Planning Application Ref: R/180/20/T

Location: Tanglewood, 3 The Parkway, Rustington, BN16 2BS

Description of works: Crown reduction to 1No. copper beech tree to height 7.5m and spread 10m

SKETCH PLAN SHOWING LOCATION OF
COPPER BEECH AT 3, THE PARKWAY, RUSTINGTON
SUBJECT TO TPO/R/01/01

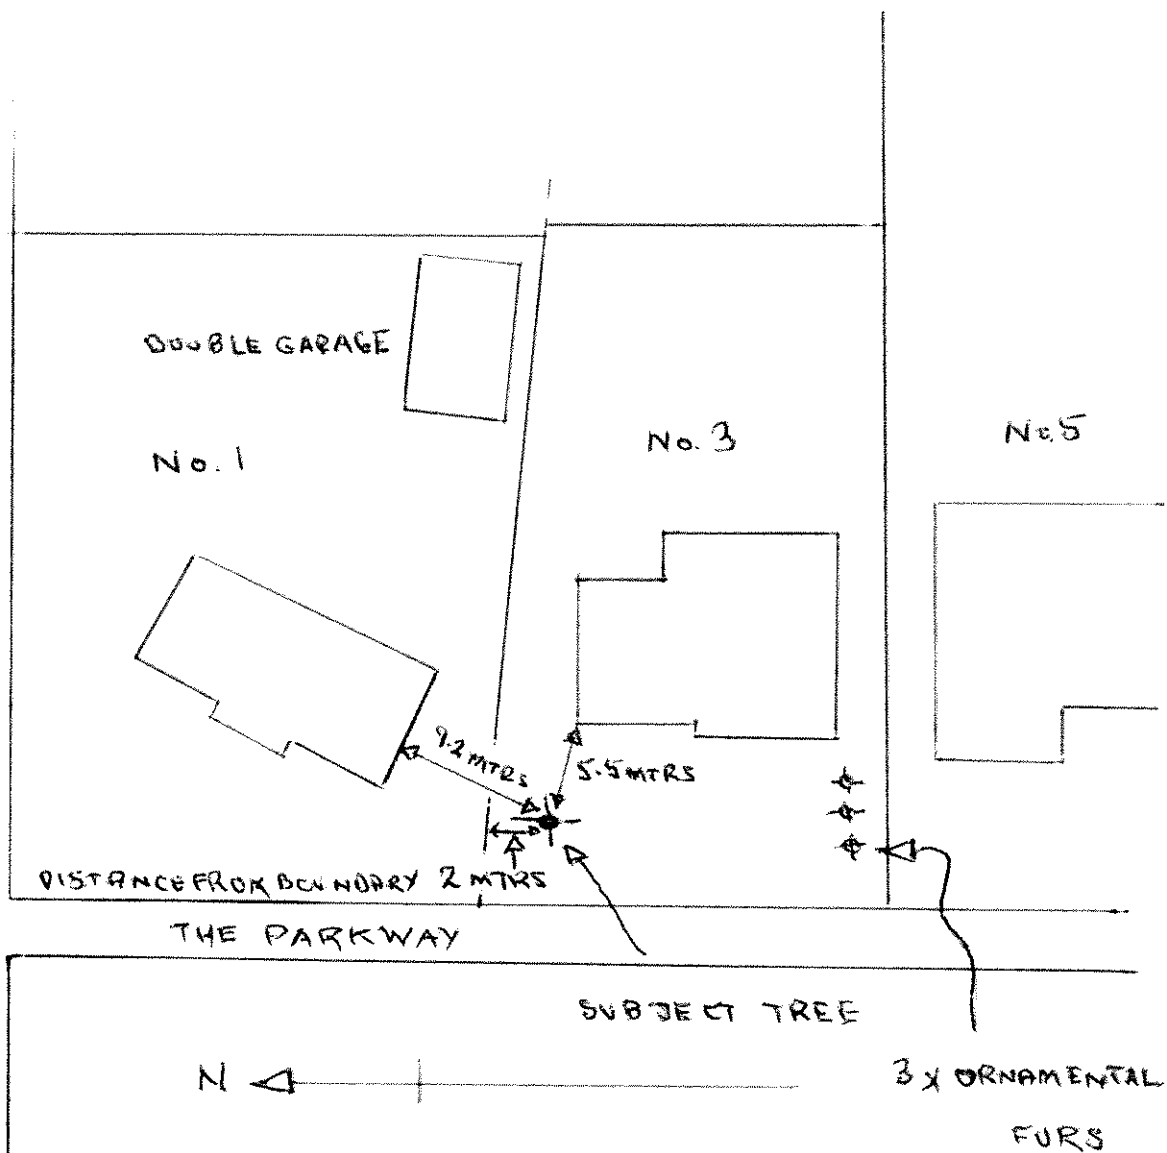
- I have had to consider this application by means of a desktop review only, using the information and plans submitted as well as online resources.
- An established tree of apparent good health albeit with a heavily modified crown. It is visible from numerous properties and to users of the highway (footway and carriageway). As such, it has public amenity value.
- Repeat operations such as now being asked for by the applicant will be necessary throughout the remaining lifespan of this tree, to achieve a reasonable degree of structural integrity appropriate for its location.

- The proposal to reduce its overall height and spread with a view to restricting its growth is justified and consistent with previous works approved by the Local Planning Authority.
- While a temporary loss of aesthetic value is inevitable, satisfactory canopy renewal and recovery should occur if the work is undertaken to a high standard and at an appropriate time of year.

- I recommend **CONSENT** for this application, subject to the following condition:

- Part a) Where whole branches are to be removed and final cuts made close to the trunk or branch union they are to be made as shown in Figure 2 of BS3998:2010
- Part b) Where branches are to be shortened back the final cuts are to be made at the correct angle shown in BS3998:2010 and adjacent to a live bud or lateral.
- Part c) The removal of crown material which has developed since the last operation must be done sympathetically and with respect to established 'knuckles' so as not to extend beyond the point of origin.
